August 6, 2013

Re: Repair Application for Septic System

HTE# 09-5-22529

Operation Permit

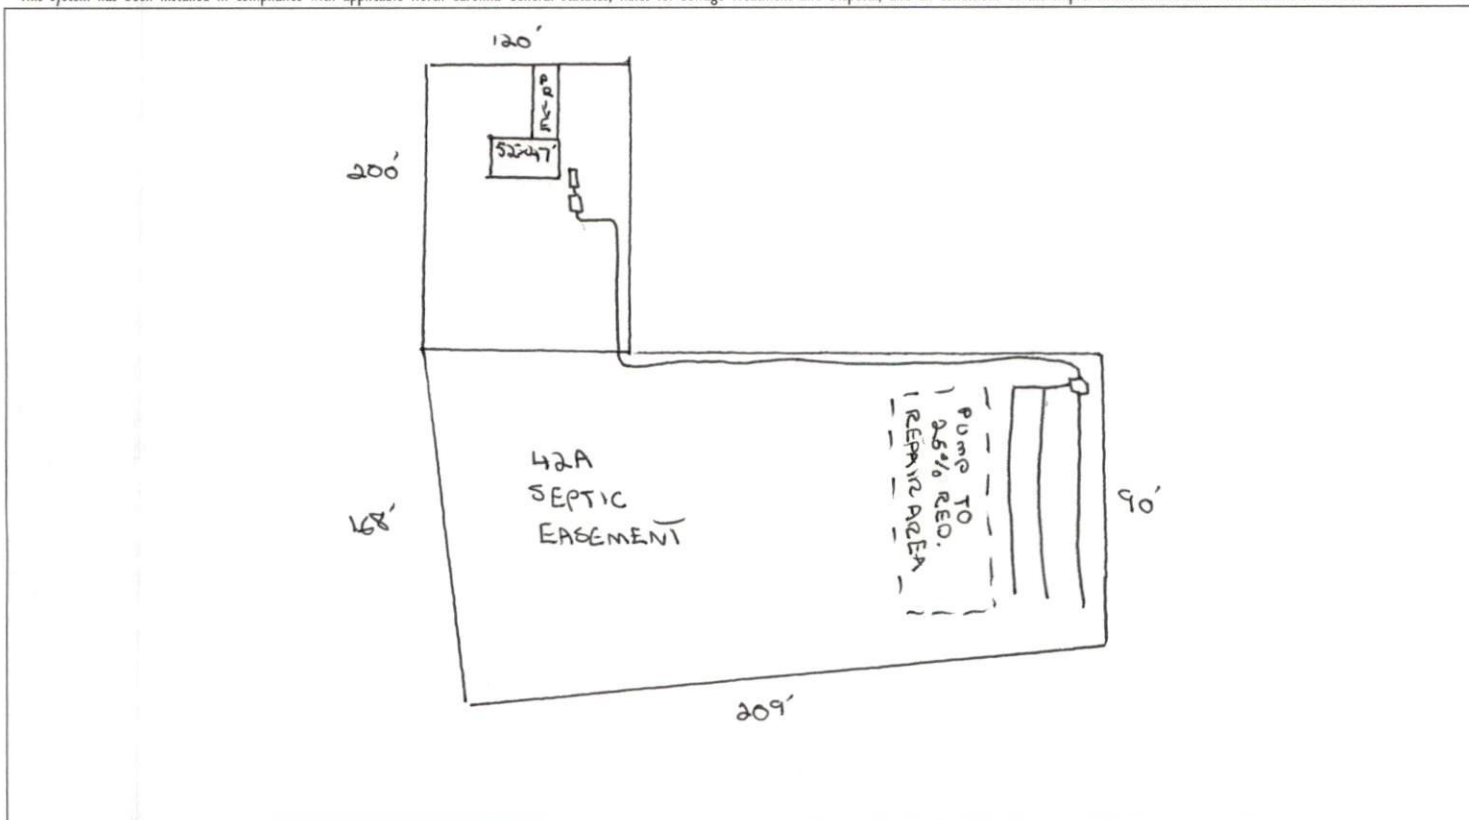
I made a site visit on August 1, 2013 to 73 Sun Ridge Drive, in the Mire Branch subdivision in response to an application for repair of the septic system. I observed a continuous stream of water running in the backyard. I initially thought the water was coming from a spring. I spoke with Oliver Tolksdorf, who issued the operations permit for the home and explained the situation to him. He called and spoke to the builder, Matt Norris with Cumberland Homes, who stated that he had installed a french drain because after digging the footing it would fill up with water. I suggest finding the end of the french drain and adding pipe to extend it past under the fence in the back. I also observed, on the inside and outside of the fence, a wet area that was dark in color. After investigating both areas, I believe that they could be the result from a spring. Both of the wet areas had a smell to them. This smell is from the organic matter in the soil not sewage. I don't believe that either area is a health hazard. Feel free to contact me if you have any other questions or concerns.

**BLACK CORRUGATED  
PIPE 24" DEEP  
NO GRAVEL  
CONSTANT FLOW  
NOT AFFECTED BY  
USE, WEATHER, AIR, OR  
NOT PART OF SEWAGE  
SYSTEM**
